**Application by Port of Tilbury London Limited for an Order Granting Development Consent for a Proposed Port Terminal at the Former Tilbury Power Station ('Tilbury2')**

**Deadline 2**

**Highways England Response to Thurrock Council's Response to First Written Questions**

APPENDIX 2: ACTIVE TRAVEL PLAN

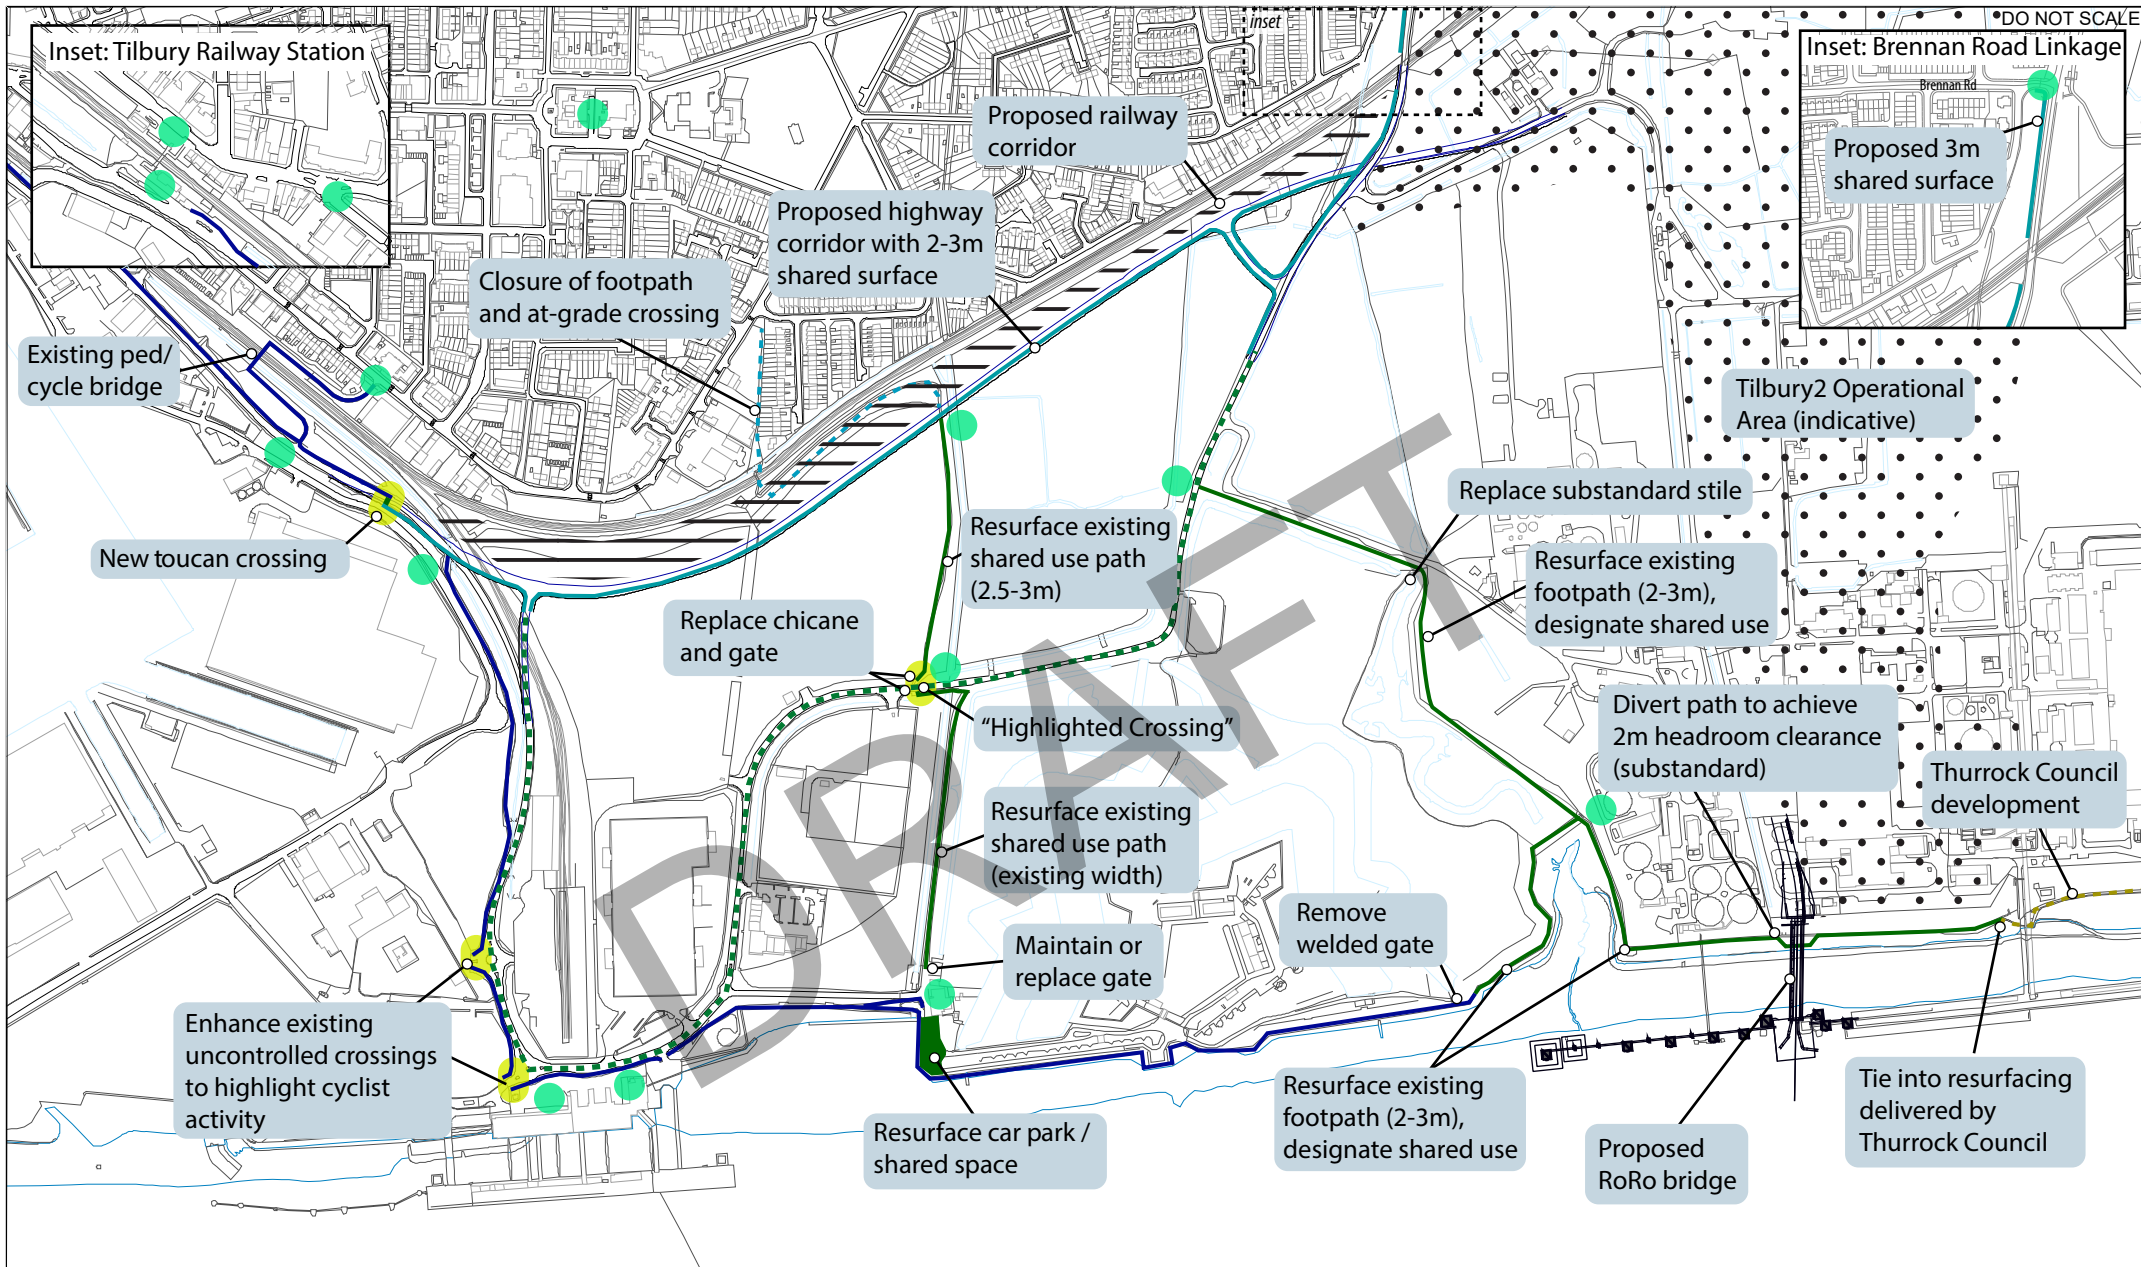
<p>ii. With regard to Active Travel provision, the proposed crossing facility should be relocated to the new junction between Ferry Road and the port access road and consideration should also be given to signalling the junction. TC notes that the Applicant suggests that the junction would operate in relation to the proposed priority junction status. However, TC is concerned that when pedestrian and cycle movements are factored into the operation of this junction, as well as the significant movements of HGVs and car between Tilbury2 and Gate 2 (existing Port pre-delivery and inspection facilities) then this would meet the criteria to consider a signalised junction with toucan phase. No assessment of this junction as a signalised junction has been forthcoming and the Applicant</p>	<p>by the site (equivalent to 439PCUs). This demonstrates that the proposed site will generate significant volumes of HGV movements in a 24hr period, with the highest volumes (97-191 per hour) being generated between 0700 and 1700. All of these trips will route via the A1089 and the Asda Roundabout. These represent very significant flow increases as a result of the Proposed Development.</p> <p>The Applicant should provide mitigation to Asda roundabout to offset capacity issues in accordance with the policy in Department for Transport Circular 02/2013.</p> <p>(ii) HE has recently improved the shared pedestrian/cycle link along the western side of the A1089 to the north of the Asda Roundabout and is also in the process of upgrading the crossing facilities on Thurrock Park Way from an informal crossing to a Toucan Crossing. HE considers that further mitigation /improvement measures would assist TC/HE to improve / join up / provide the</p>

is encouraged to undertake this assessment. With reference to proposed cycle links along the port access road, these appear to terminate at the point where Fort Road starts to progress north over the existing railway over-bridge. The existing bridge structure does not have sufficient road space to provide a cycle facility and no footways exist on the north side of the bridge linking to Brennan Road. TC has requested that the Applicant consider a potential onward link to Brennan Road, particularly as TC has aspirations to designate National Cycle Network 13 through the centre of Tilbury, along Brennan Road and then south to Tilbury Fort along Fort Road. This is considered as suitable mitigation against the closure of the at-grade crossing facility (FP 144) between the Hairpin Bridge and Fort Road bridge by maintaining two enhanced facilities for pedestrians and cyclists to access the riverside and Tilbury-Gravesend ferry.
